Your ref: EN020026
My Ref: 2026-09-11 Sea Link SoS.docx

My submitted Sea Link document refs:
Interested Party 
Relevant Representation RR3944
[REP3-132]
[REP4-240]
[REP6-256D]
Deadline 7: Response to REP5-137, submitted 6 May 2026

**RESPONSE TO THE SECRETARY OF STATE'S REQUEST FOR INFORMATION, DATED 28 AUGUST 2026
SEA LINK - SUFFOLK**

Document Title: BARE EARTH ZONE OF THEORETICAL VISIBILITY - CONVERTER STATION SITE 1

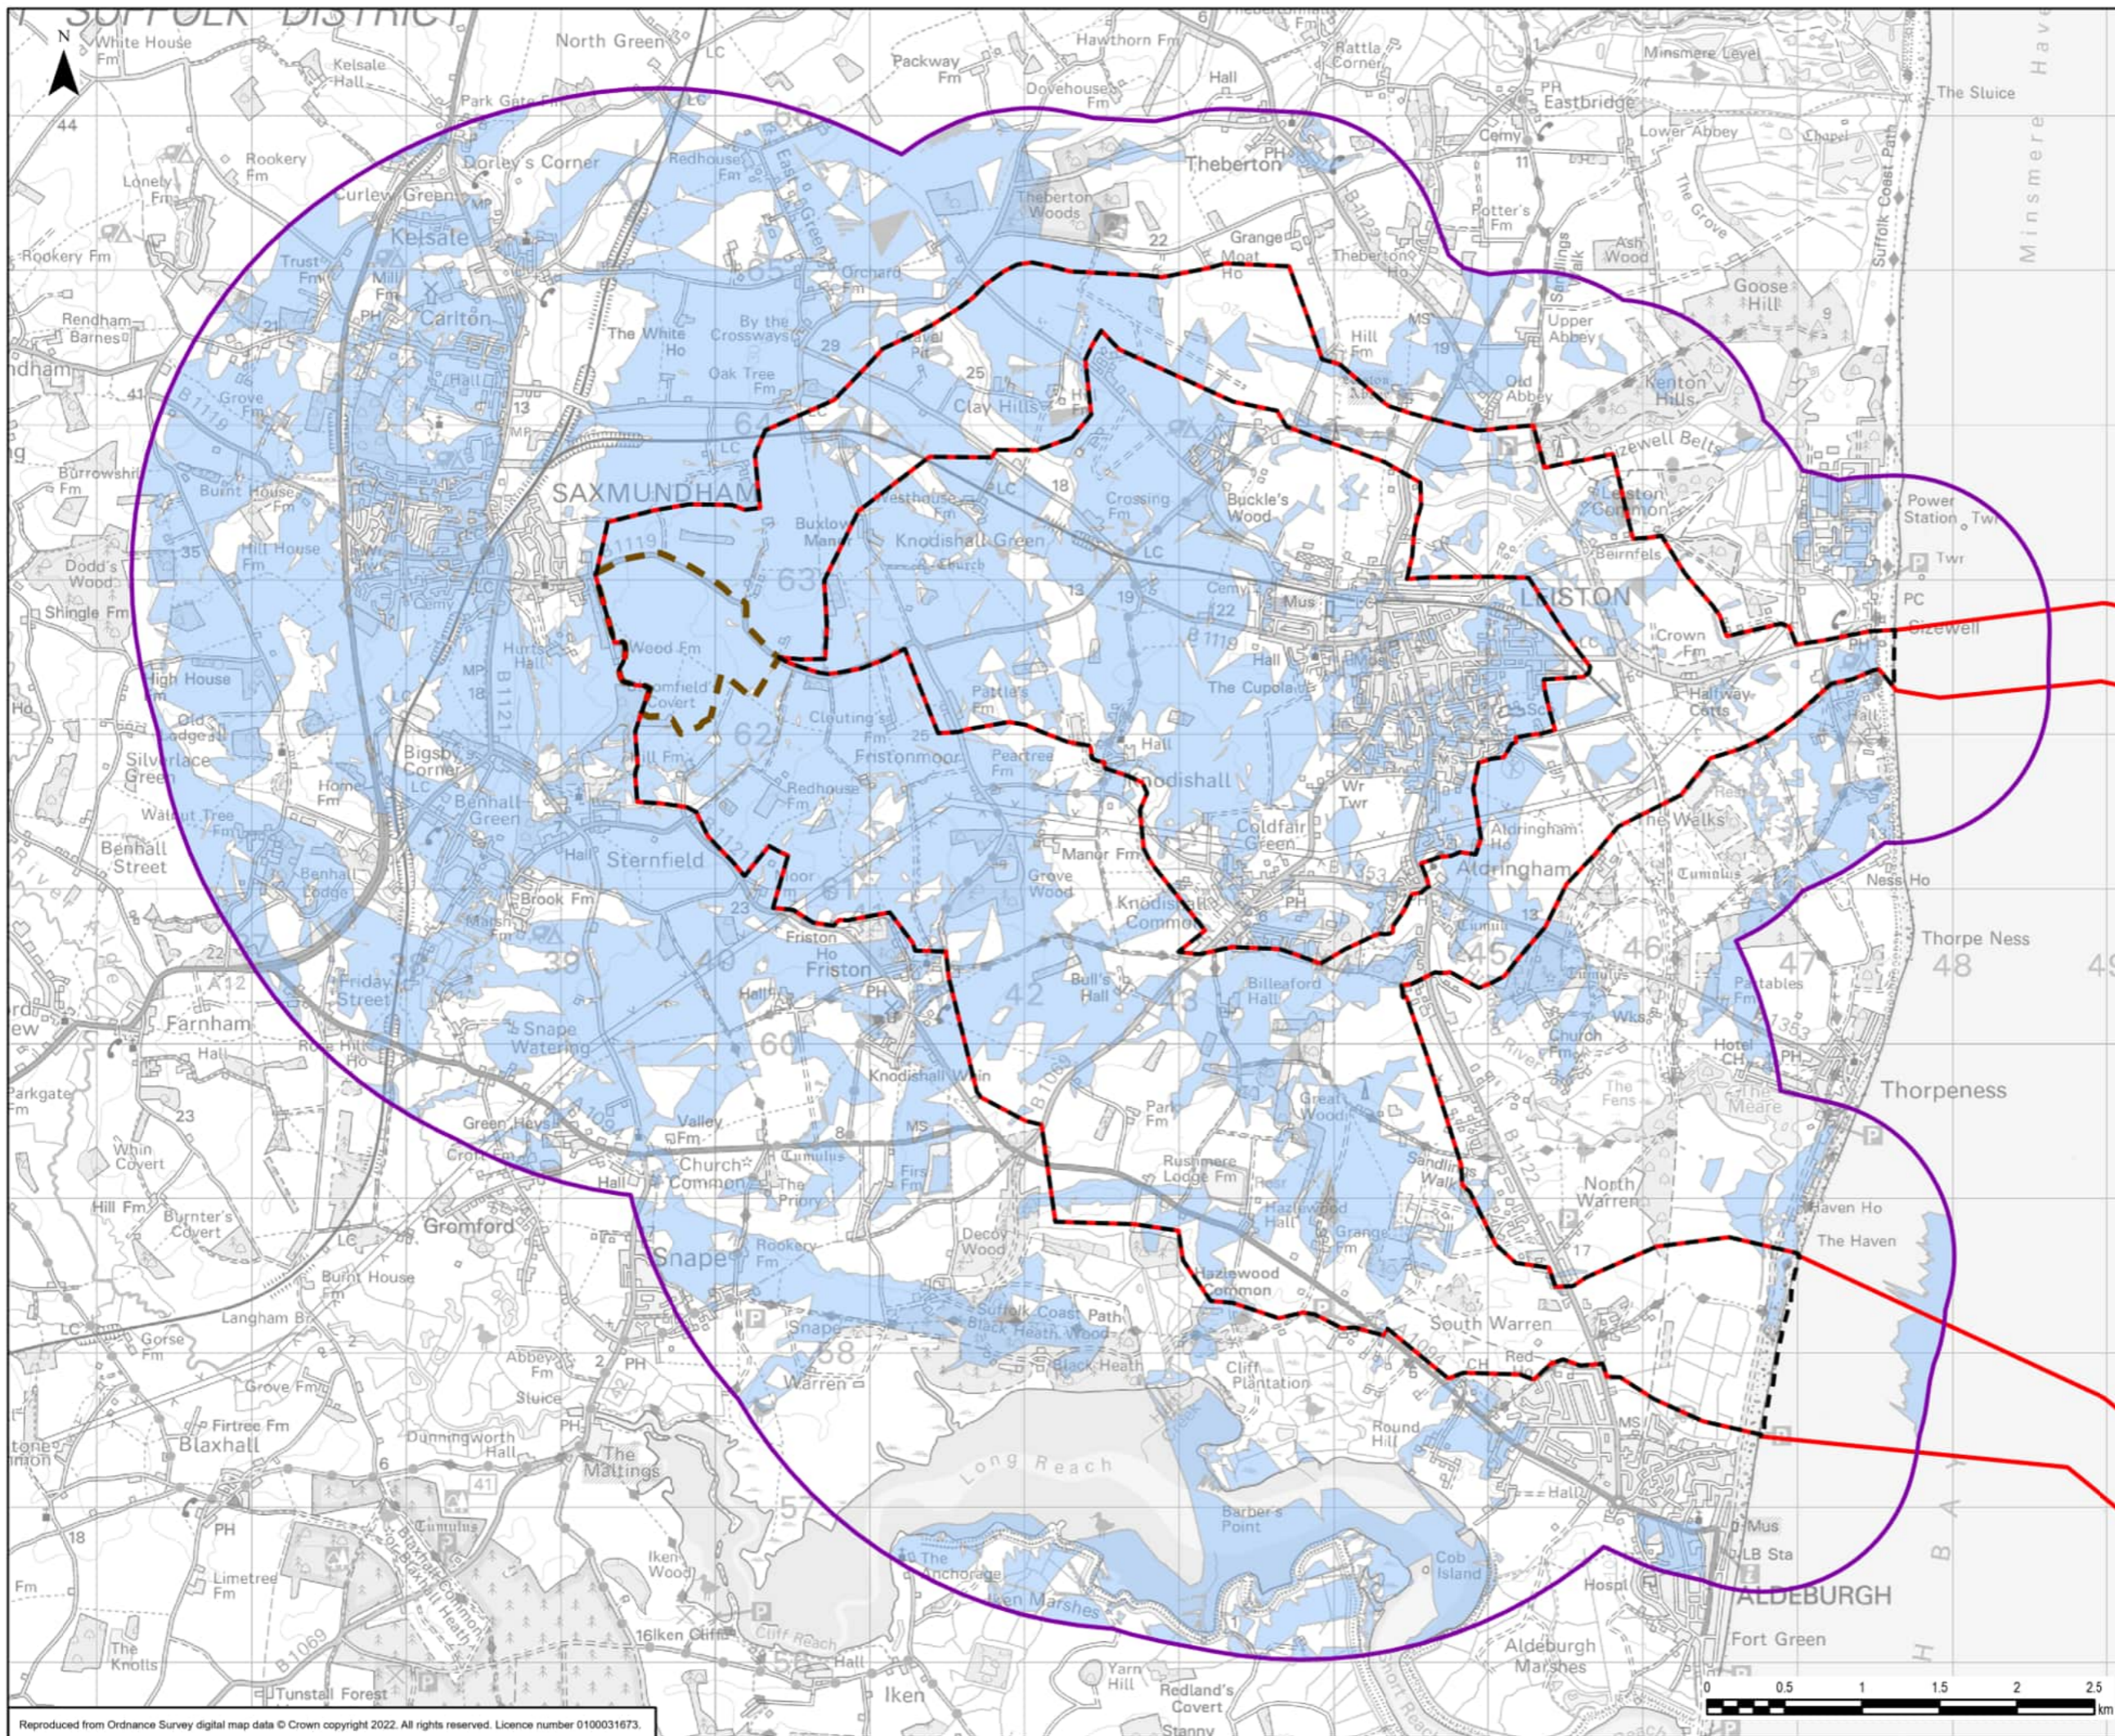
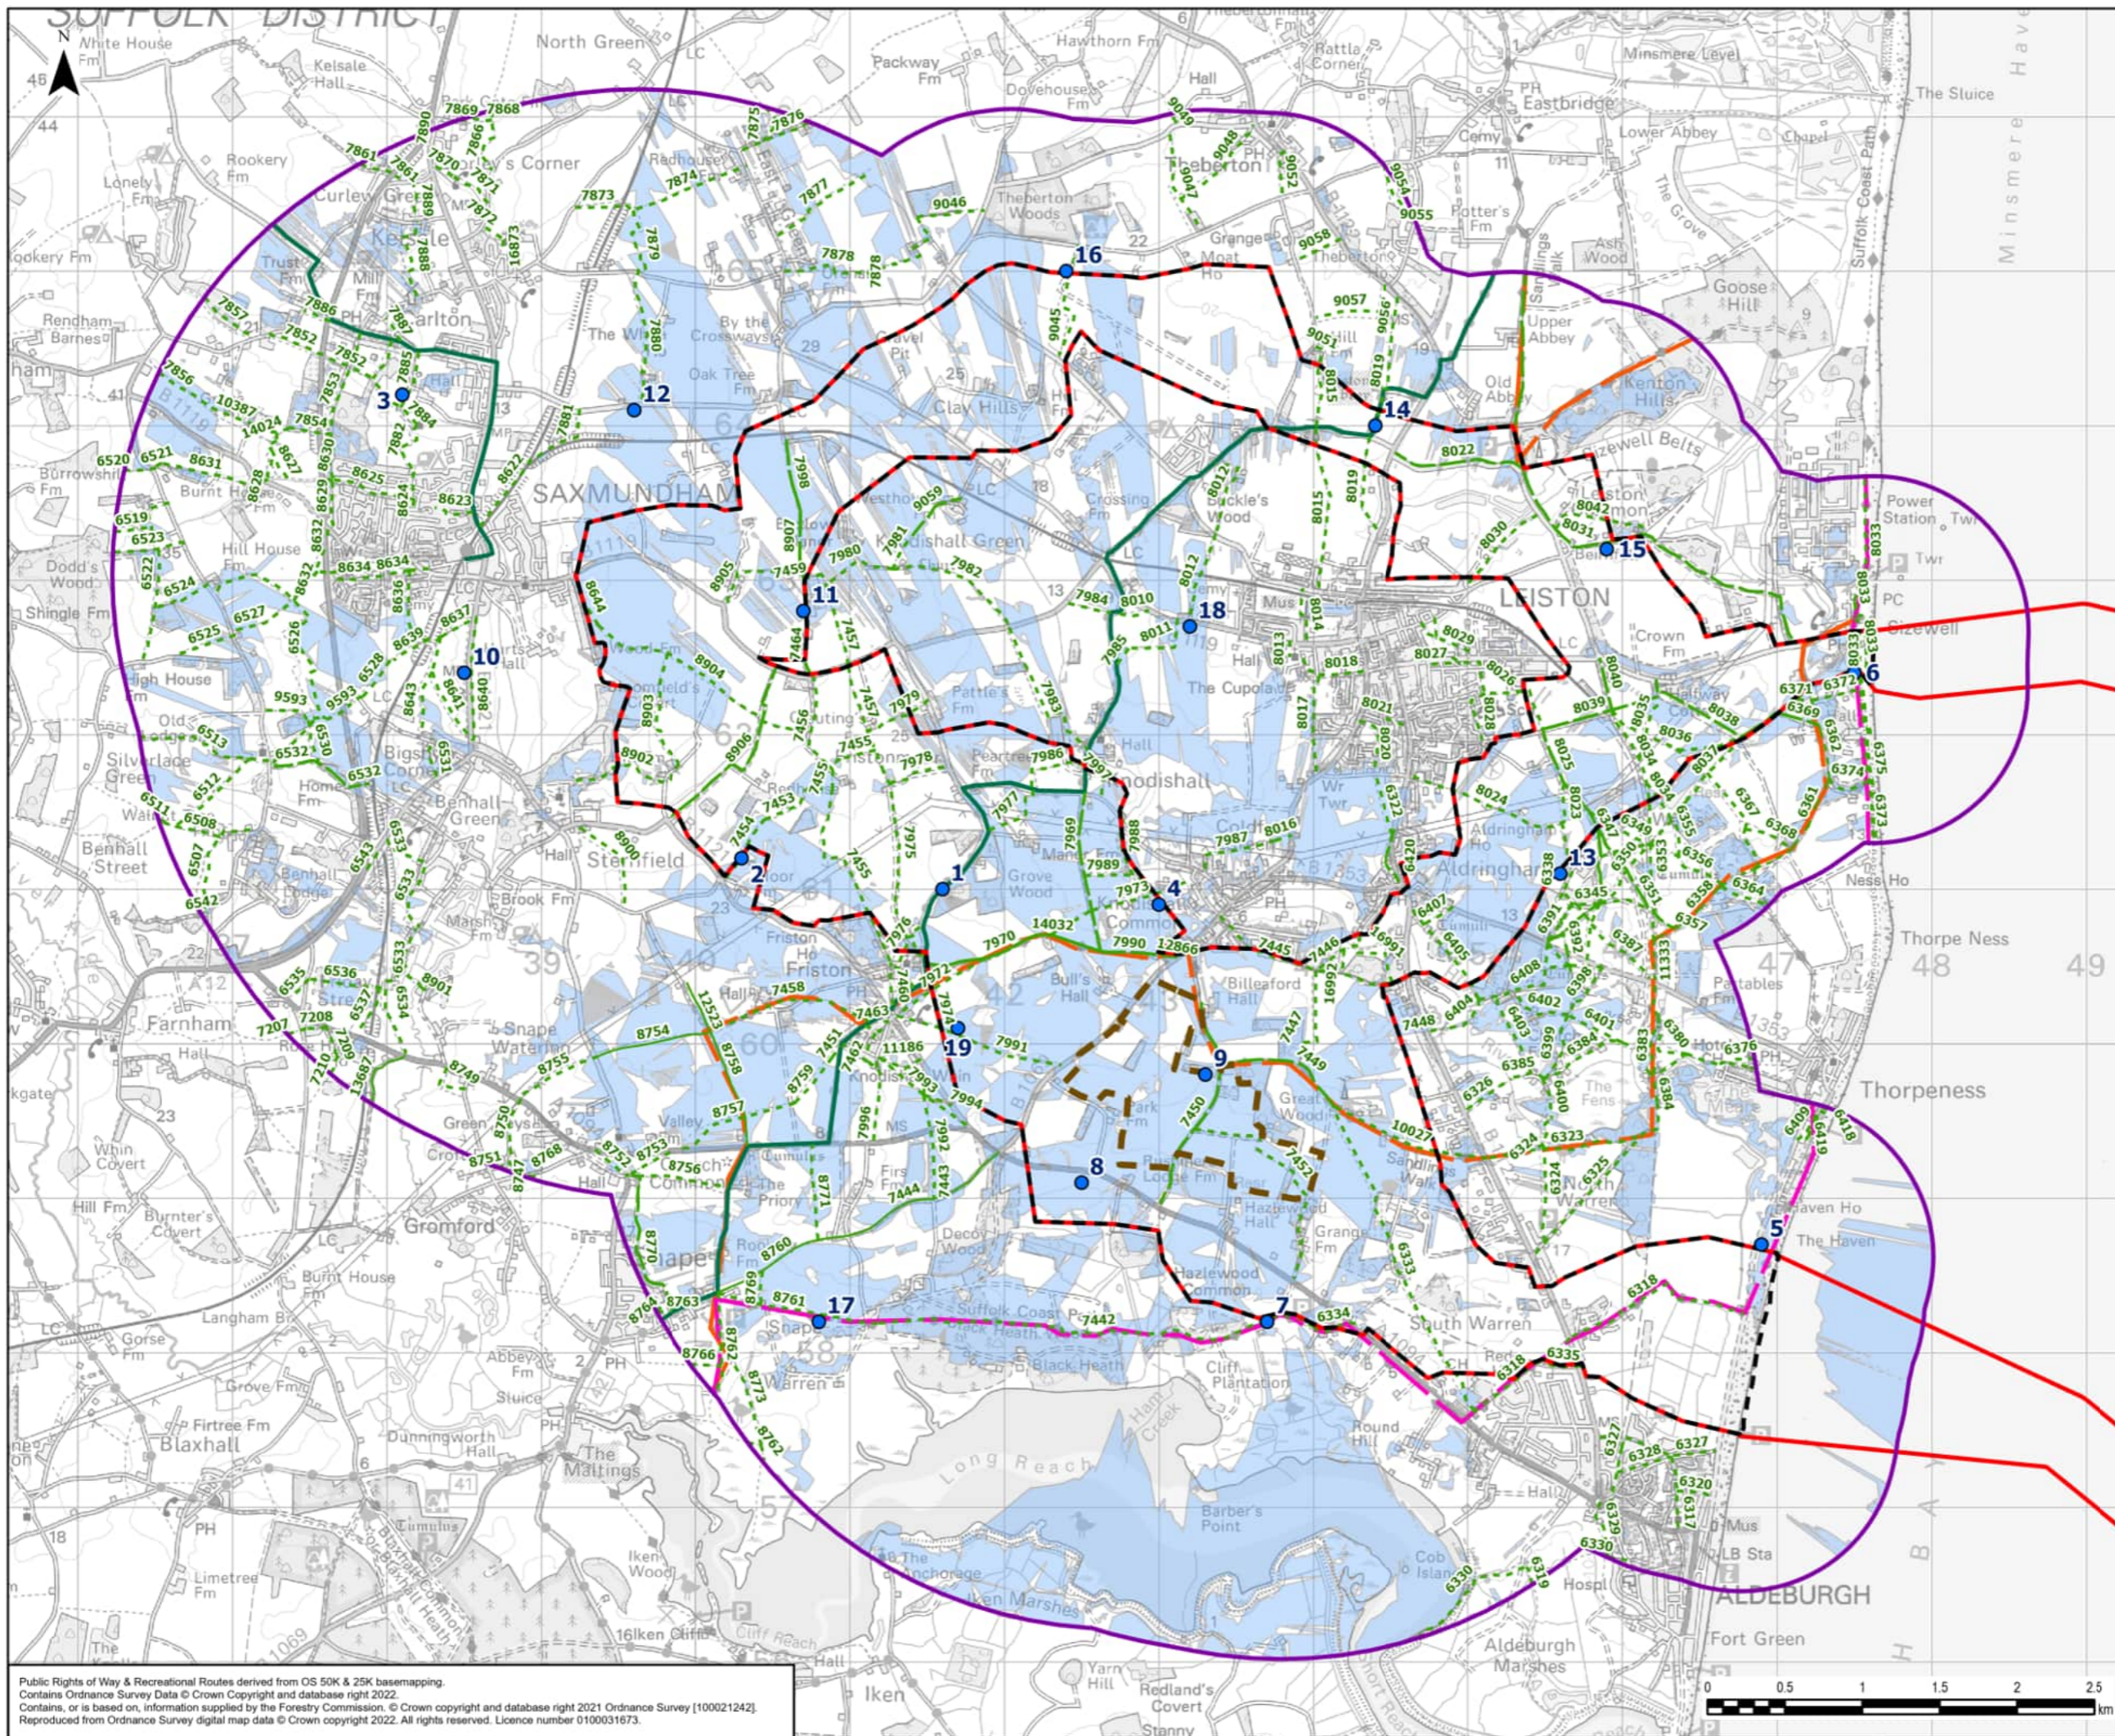
- The Area of Search has been drawn far too narrowly for the is topic
- The inconsistent construction of the Zone of Theoretical Visibility (ZTV) CAD plans in the PEIR and DCO submissions I identified and illustrated in my **[REP6- 256D]** has not be adequately explained by the Applicant

- Any conclusions about the visibility of the Project outside the Area of Search within the National Landscape and the consequent potential effects are still at large. This is a serious question mark on the validity of this aspect of the LVIA
